IN THE MATTER OF AN APPLICATION FOR DEVELOPMENT CONSENT IN  
RESPECT OF STONESTREET GREEN SOLAR FARM PINS REF EN010135

COUNSEL'S NOTE

1. I provide this note for the Aldington and Bonnington Parish Council in connection with the commencement of the Examination of the Stonestreet Solar Development Consent Order Application (“Application”). I deal briefly with the stage that we have reached in the procedure, and then provide my initial comments on the draft Development Consent Order itself (“dDCO”).
2. I note at the outset that I have been instructed by another party to advise in relation to the Application which has given me some background information about the Application. I do not consider that there is any conflict of interest in advising the Parish Council on this limited set of instructions.

Project Name:
 Stonestreet Green Solar
 Drawing Title:
 Works Plans
 Sheet 3 of 5
 Drawing Number:
 142-02-44-pg3
 Scale: 1:2000@A1 APPF Reg. 5(2)(j)
 Produced: RC Checked: Quod Date: December 2024 Version: 03

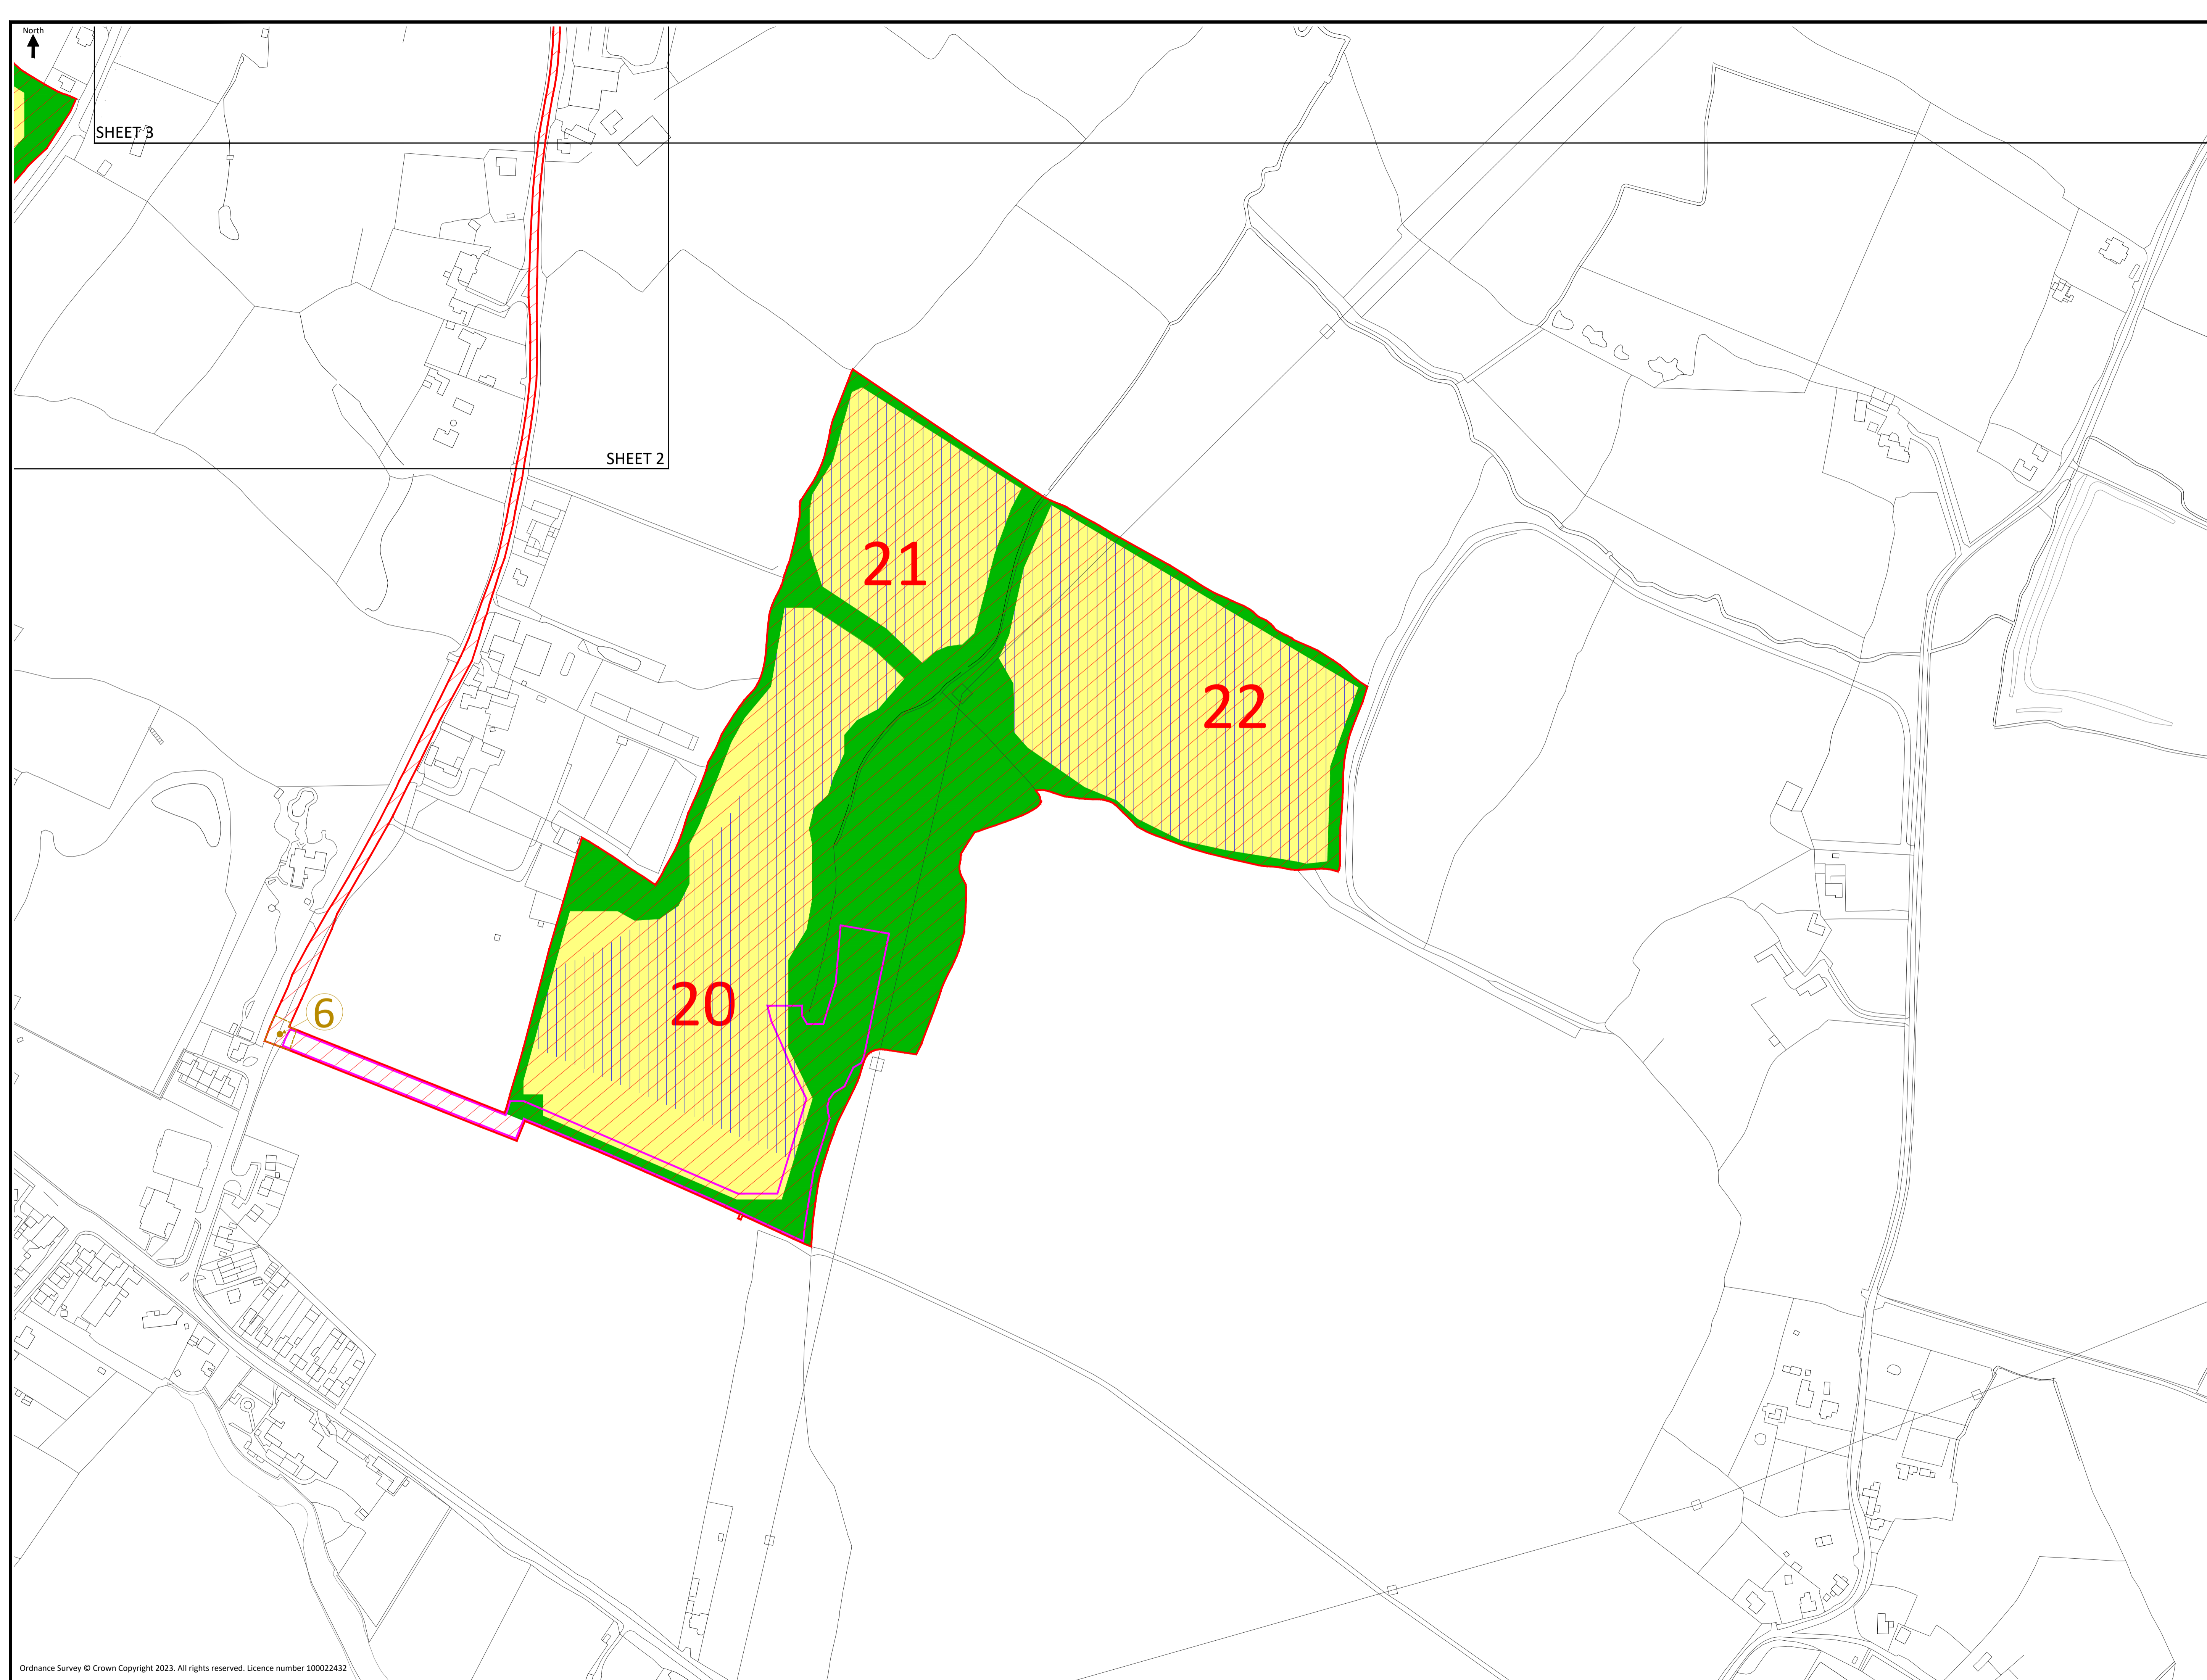
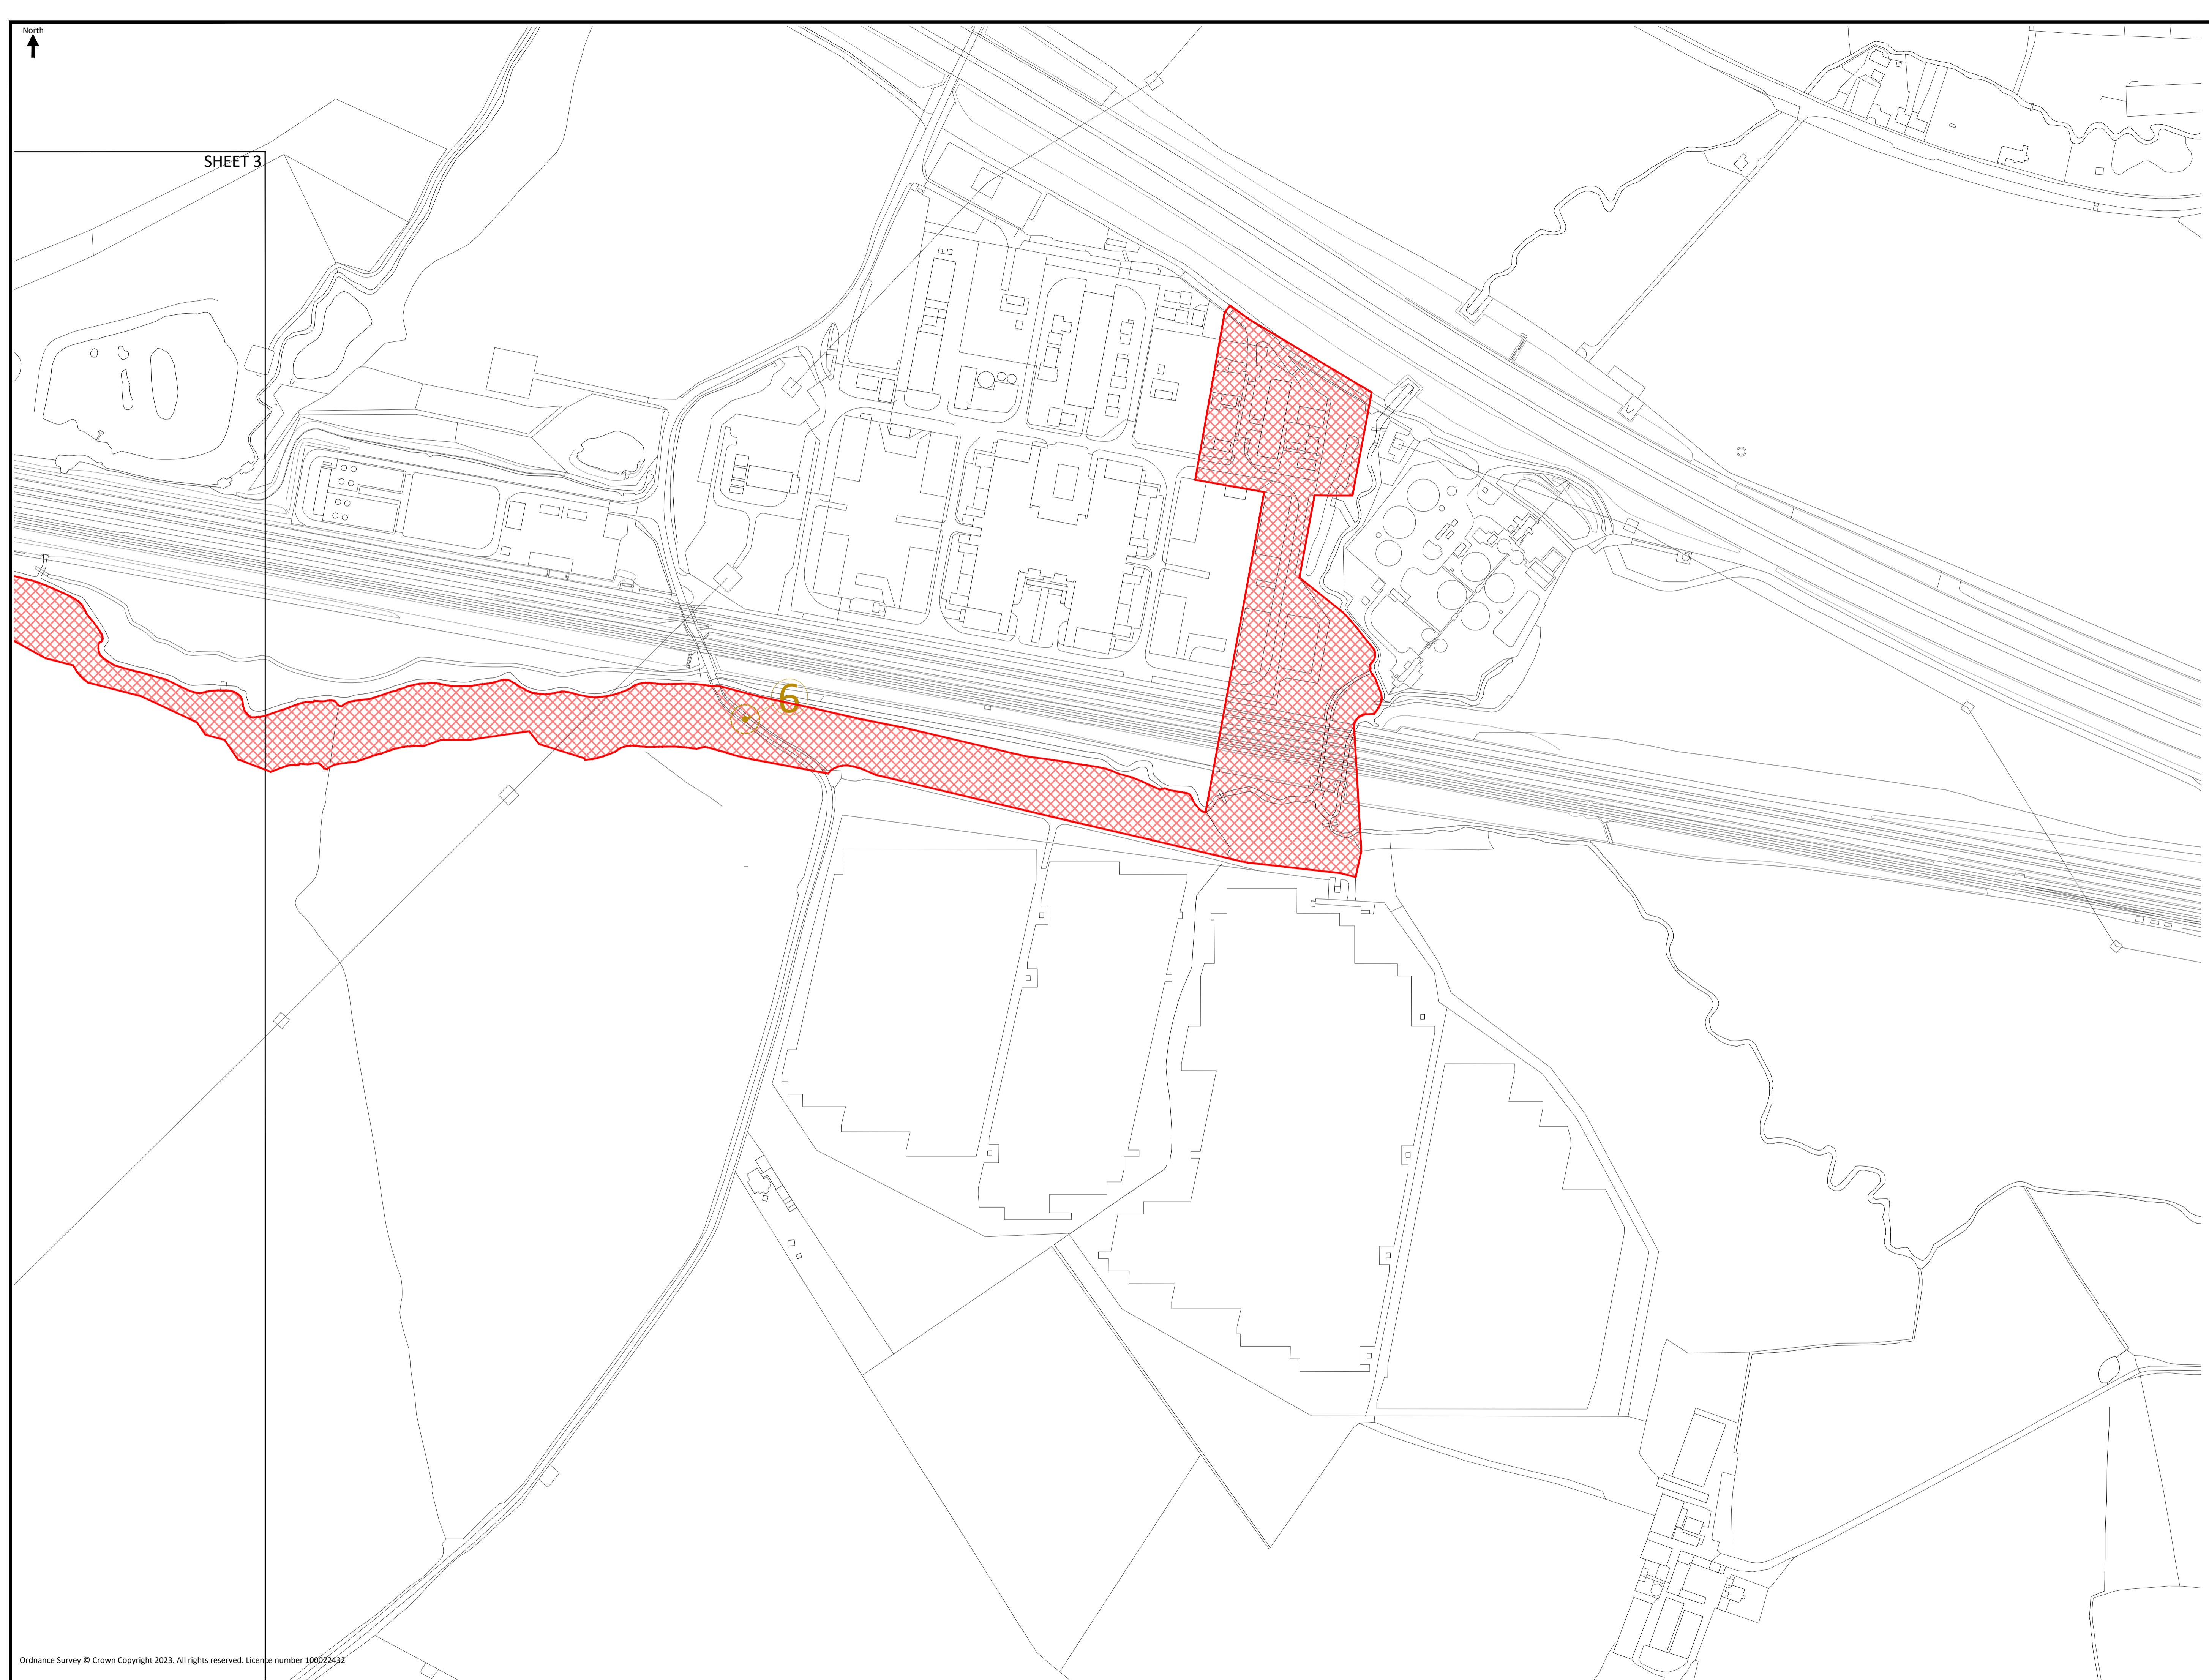
11. This is important, as the Work Plans which accompany the dDCO are incredibly generic about the location of key elements of the scheme, merely providing an indicative hatching across most of the site for both the solar array (Work 1) and the battery component of the scheme (included within Work 2).

14. Secondly, given that there is no number of or approximate locations for the battery storage and connected elements of the scheme, I find it difficult to understand how the Rochdale envelope can be robustly created – is the Applicant going to assume as a

worst-case scenario that *all* the land hatched on the Work Plans for Work 2 will be occupied by batteries and their infrastructure? That would on one level be absurd, but on another, if there is an unlimited number of batteries permitted across that whole area, then that is what the Rochdale envelope requires to be assessed.
